RE: SUBMISSION TO SSD-82900461, CONCEPT PROPOSAL FOR CONSTRUCTION OF 9 STOREY RESIDENTIAL FLAT BUILDING WITH IN-FILL AFFORDABLE HOUSING

Address: 11-19 Middle Harbour Road, Lindfield

Ku-ring-gai Council's objection to SSD-82900461, Concept proposal for construction of 9 storey residential flat building with in-fill affordable housing at 11-19 Middle Harbour Road, Lindfield

Figure 2 Proposed Height Banket Diagram.

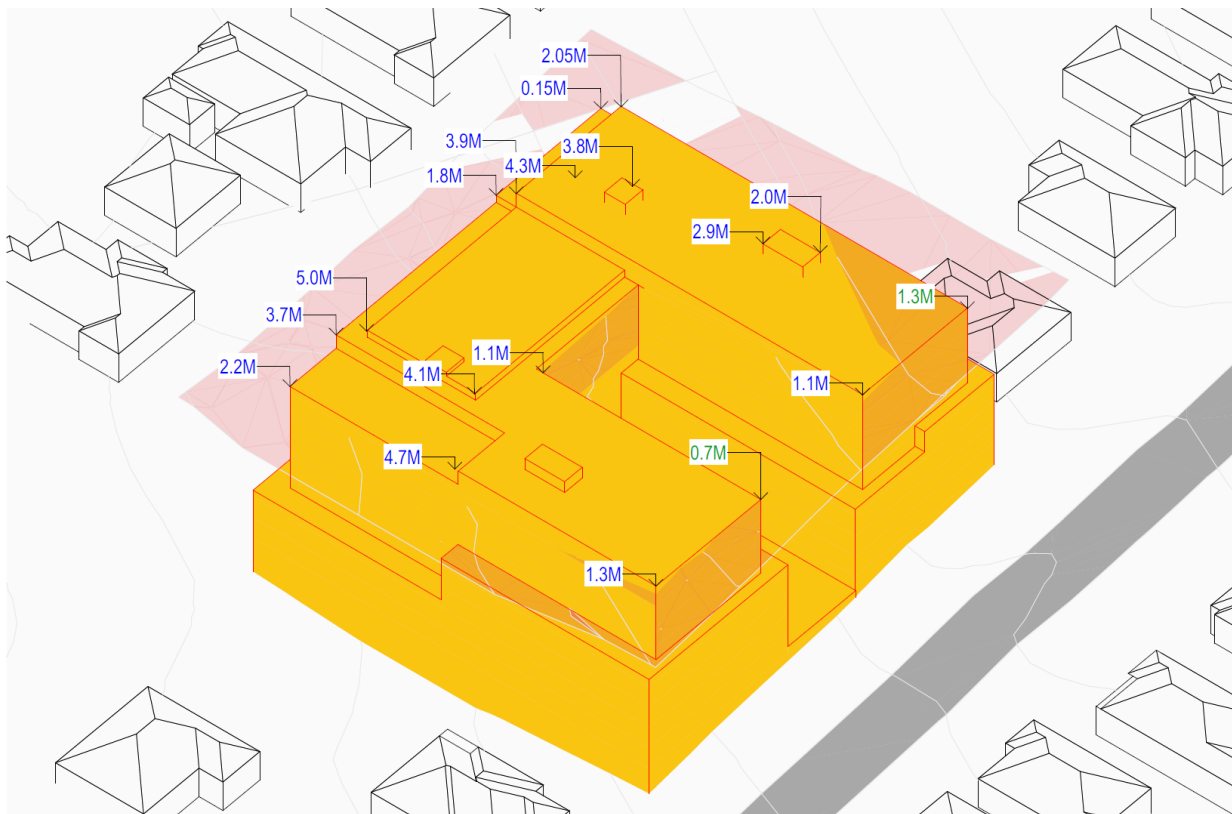
The proposed building height of 33.6m exceeds the maximum building height of 28.6m permitted under Chapter 2 of the SEPP (Housing) and represents a variation to the maximum building height of 18.5m in Council's Plan.

Drawing Name
Basement 01

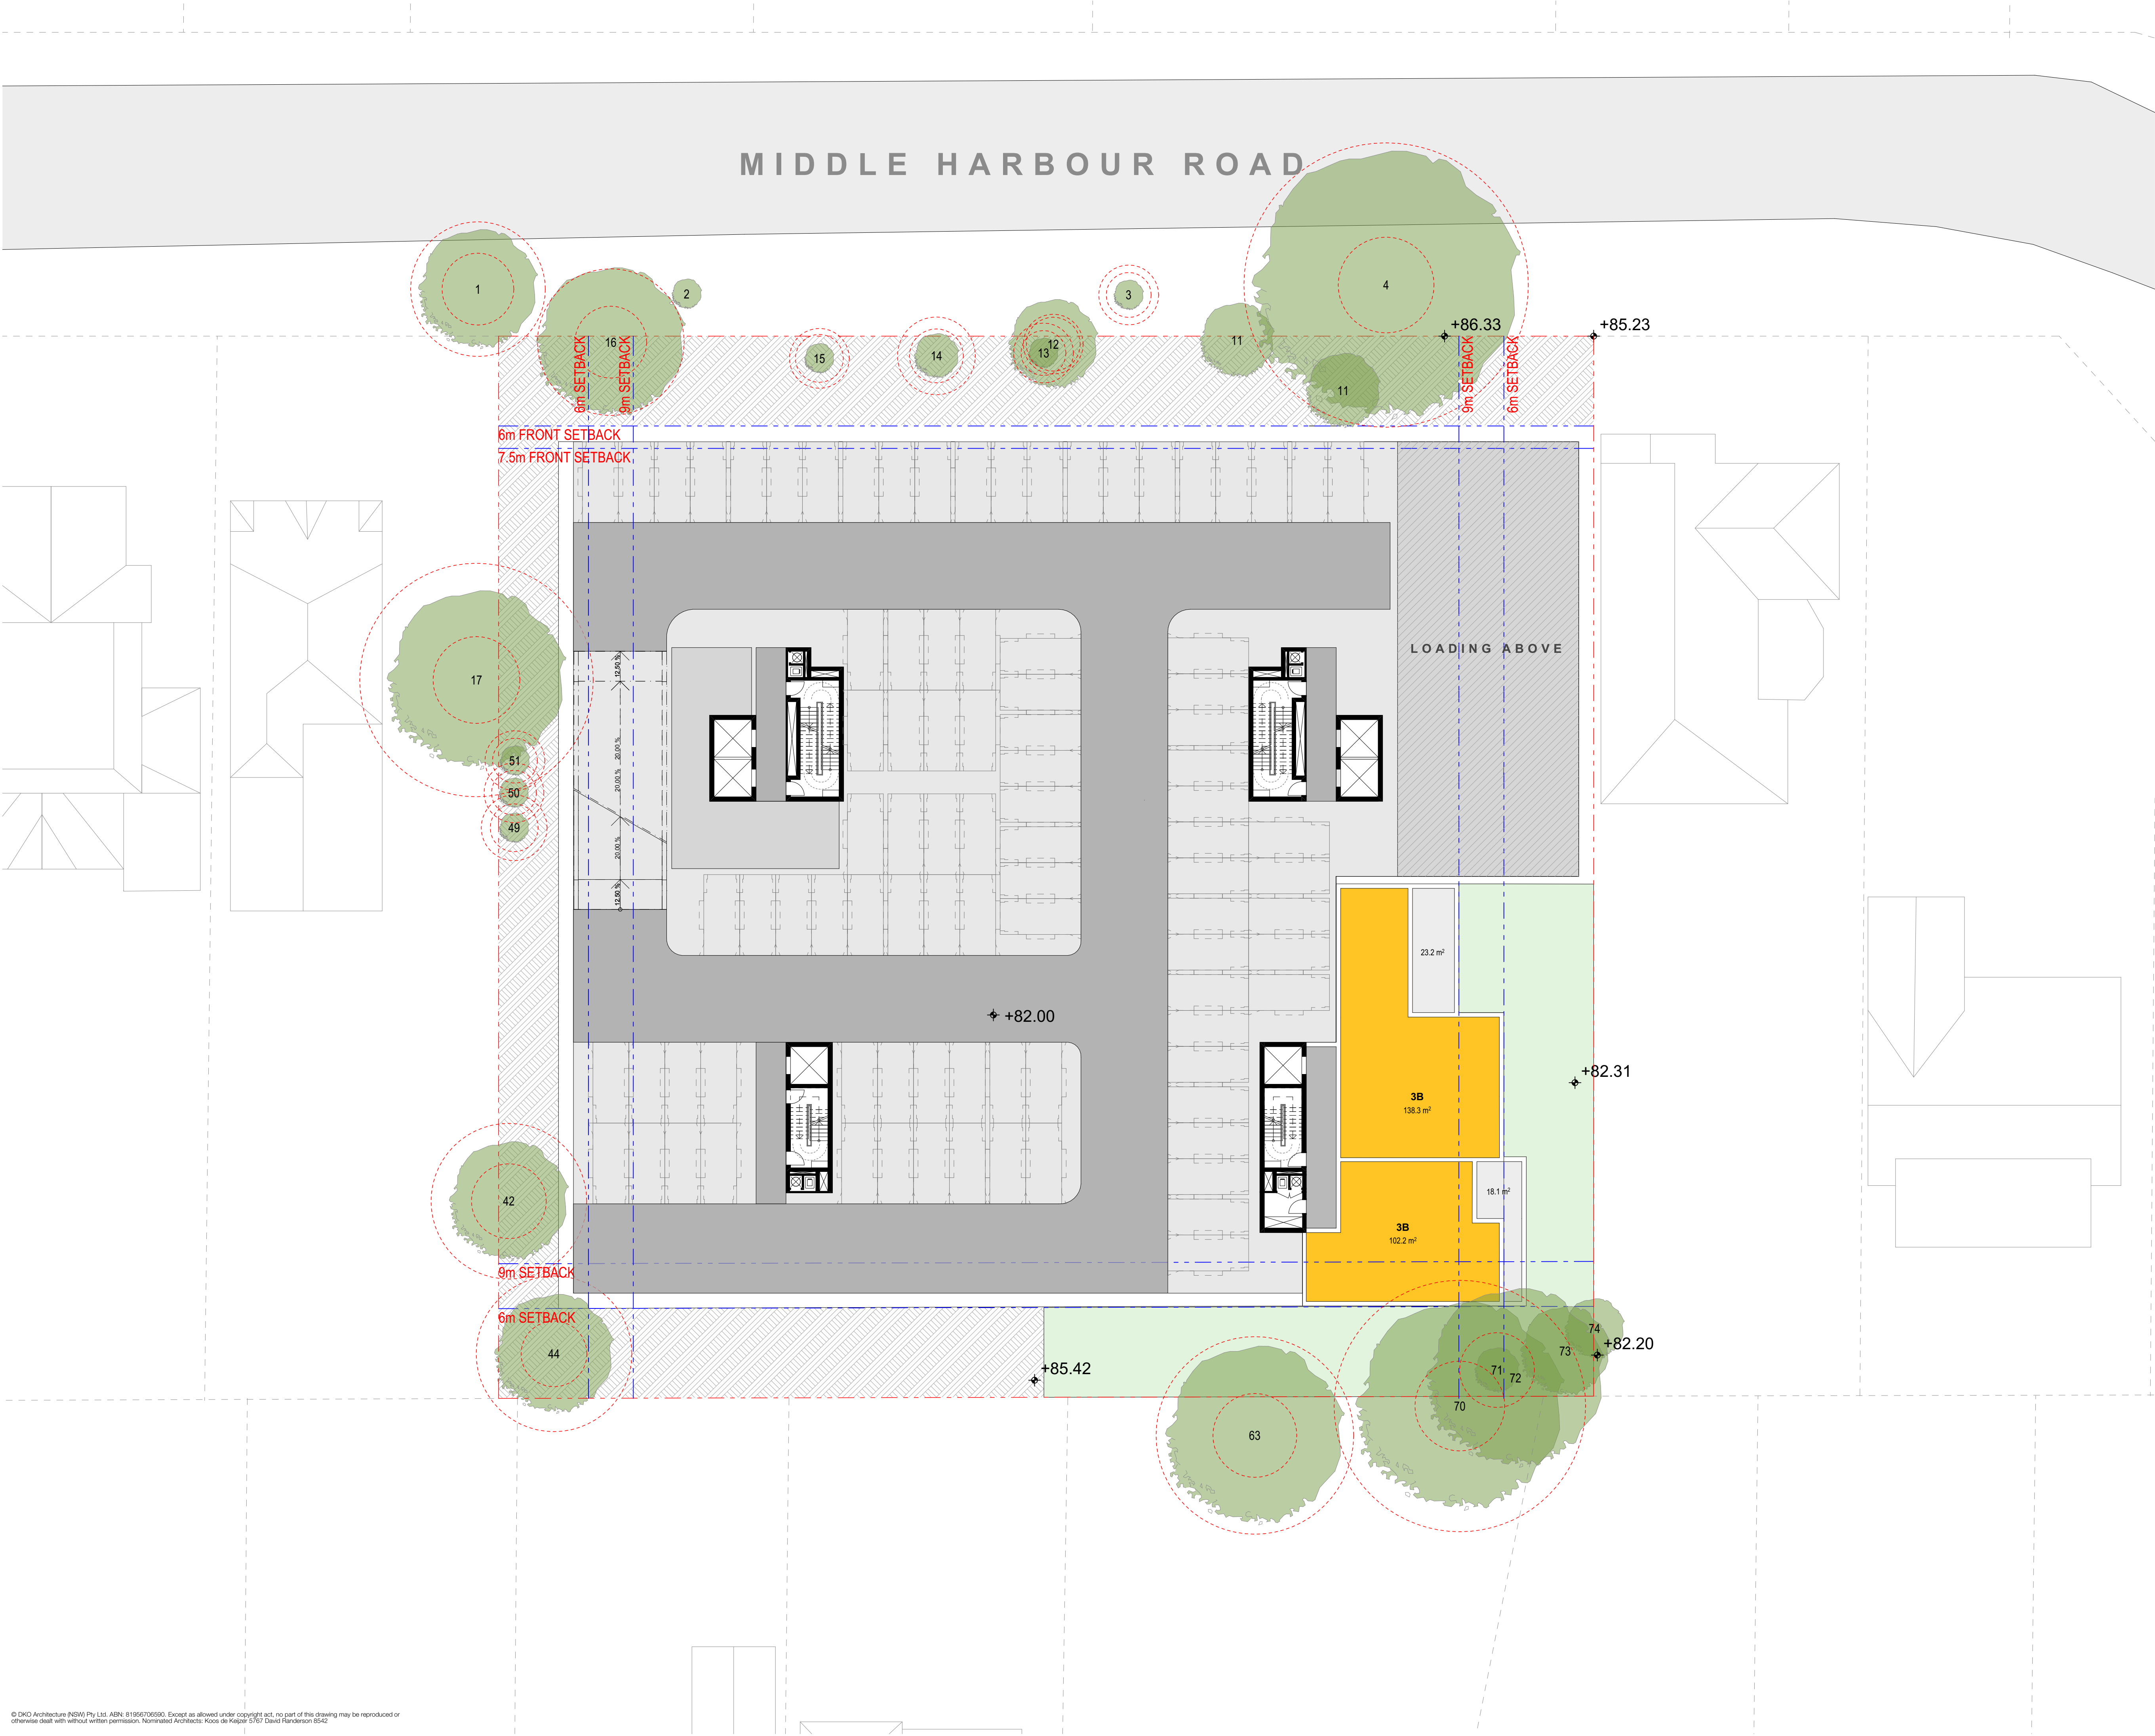
The basement car parking levels have nil setback to the eastern side boundary and is setback 4m from the western side boundary. The proposal does not comply with the minimum side setbacks controls in the KDCP and will impact on available deep soil areas along the side boundaries, limiting the planting of tall trees and screen planting. The proposed basement levels will have adverse impacts on landscaping within the site consequently impacting the landscaped character of the locality.

- The setbacks of the basement levels, particularly to the front and side boundaries, are to be contained within the building footprint to achieve minimum deep soil areas and dimensions for tall tree plantings and screen planting.

- The proposed driveway is to be set back from the eastern side boundary by at least 6m to provide deep soil and sufficient tree planting and screen planting adjacent to the adjoining property.

Deep Soil Calculation

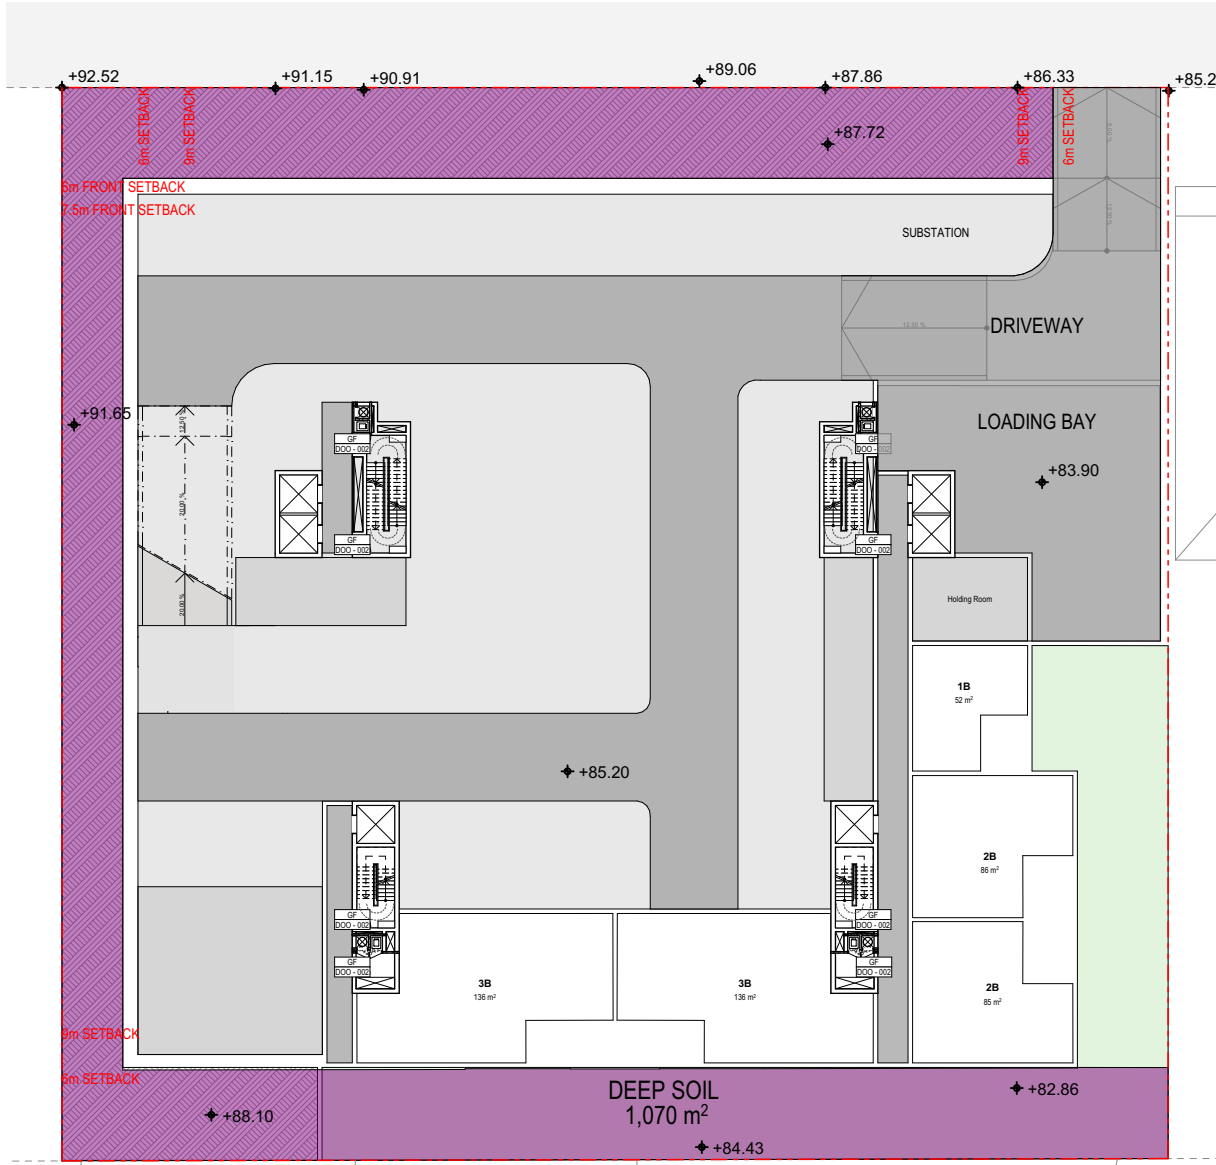
The architectural and landscape plans have incorrectly identified deep soil zones along the eastern and western side setbacks. The areas calculated as deep soil are contrary to the definition in the SEPP (Housing) which reads as follows:

As the basement levels encroach the side setbacks, the areas containing basement structures cannot be included as deep soil area. Future built elements such as retaining walls, pathways and service infrastructure are likely to impact areas for deep soil and require further design resolution before it can be determined if compliant deep soil areas are provided.

1. SITE COVERAGE 1:500

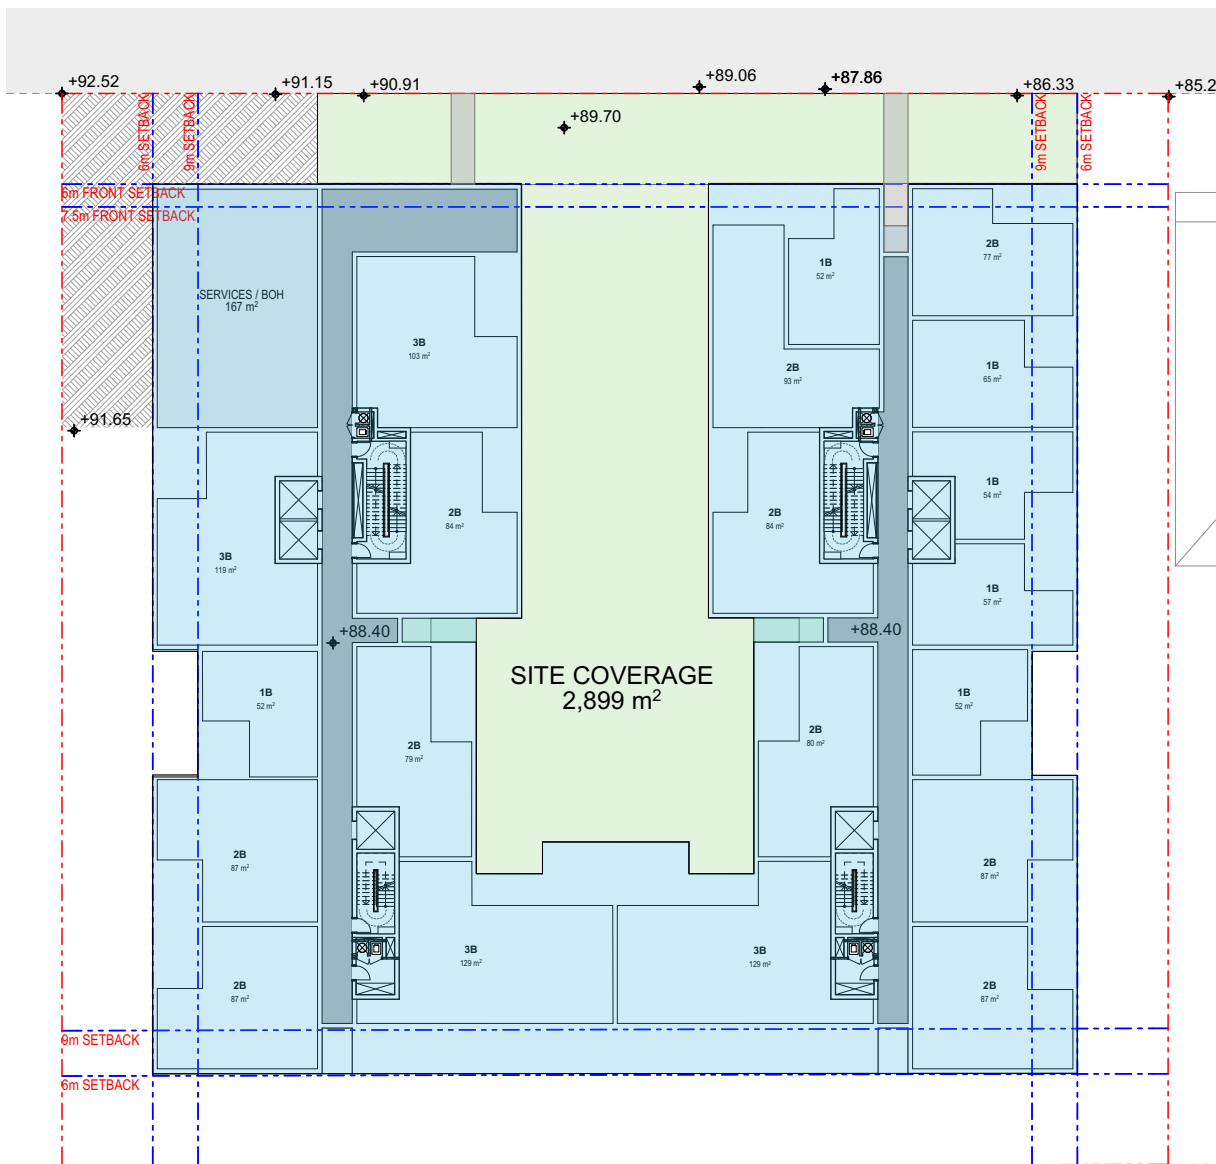
The proposal has a site coverage of 56% (5,187m²), which substantially exceeds the maximum site coverage control of 30% in Part 7A.5 KDCP. The proposal presents an overdevelopment of the site, both visually and functionally. The proposal does not demonstrate a suitable building envelope or footprint that is suitable for the site and capable of achieving sufficient deep soil and landscape areas.

1. LEVEL 01 COS 1:500

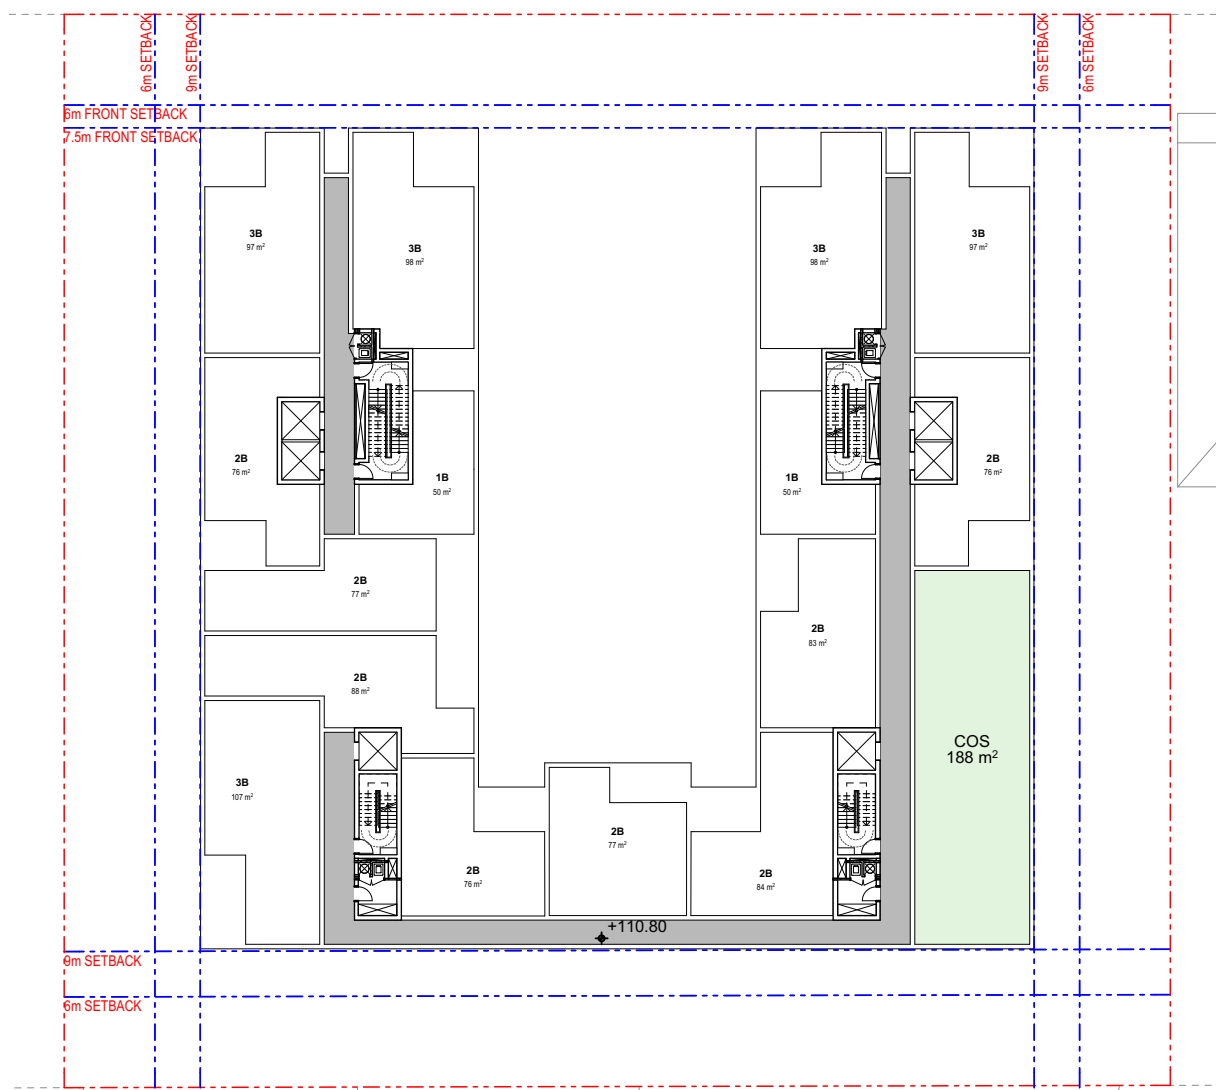
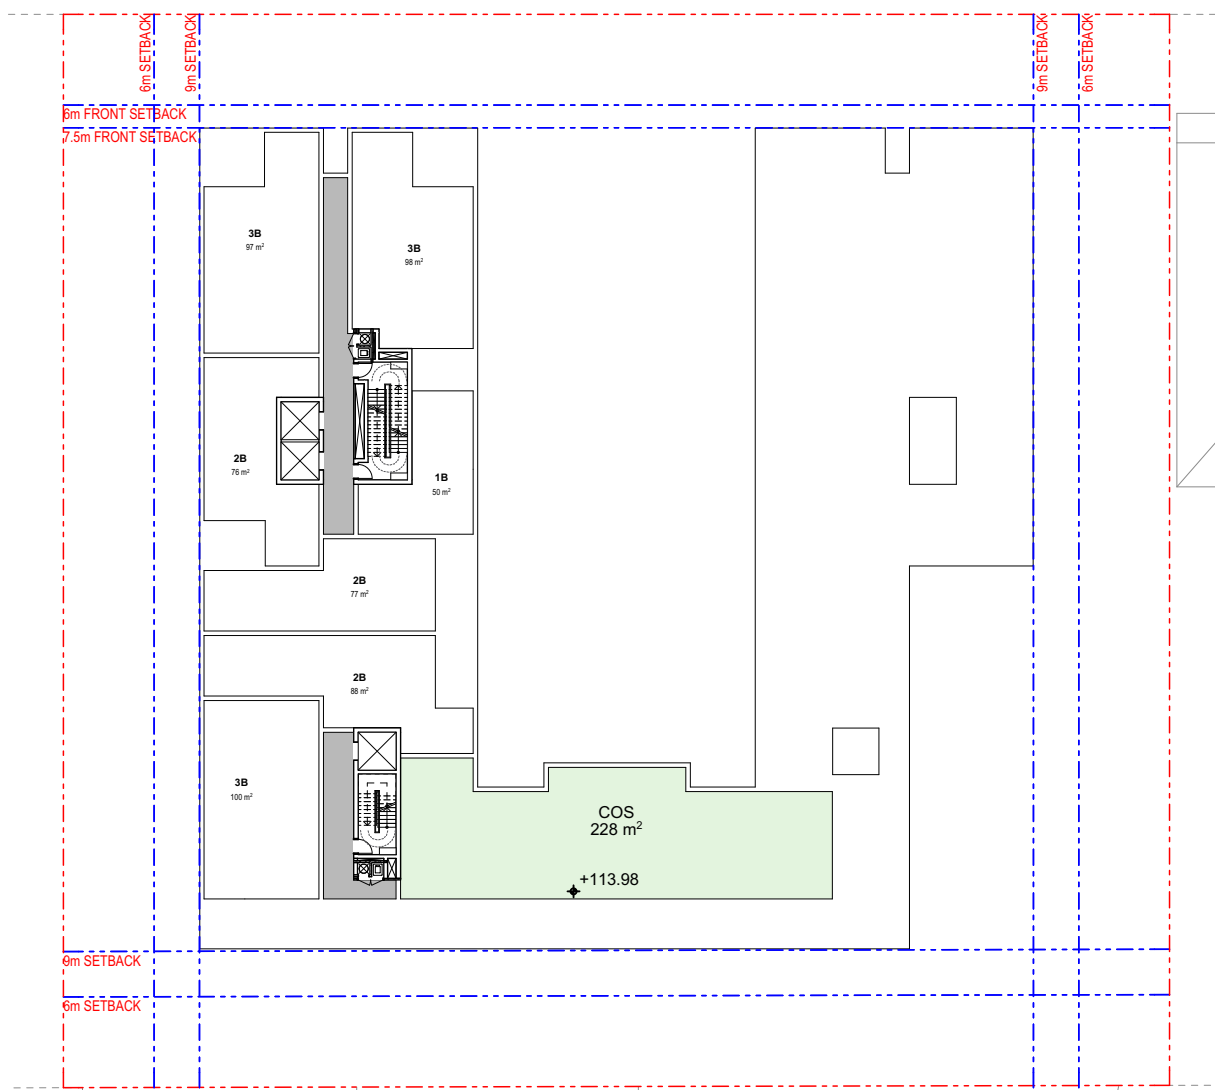
The calculation of communal open space areas on the architectural and landscape plans are inconsistent and it cannot be determined if the proposal achieves the minimum communal open space area for the site. In particular, the Level 1 architectural plan shows the communal open space including the landscaped area within the front setback however, the front setback area has been identified as private open space on the landscape plans.
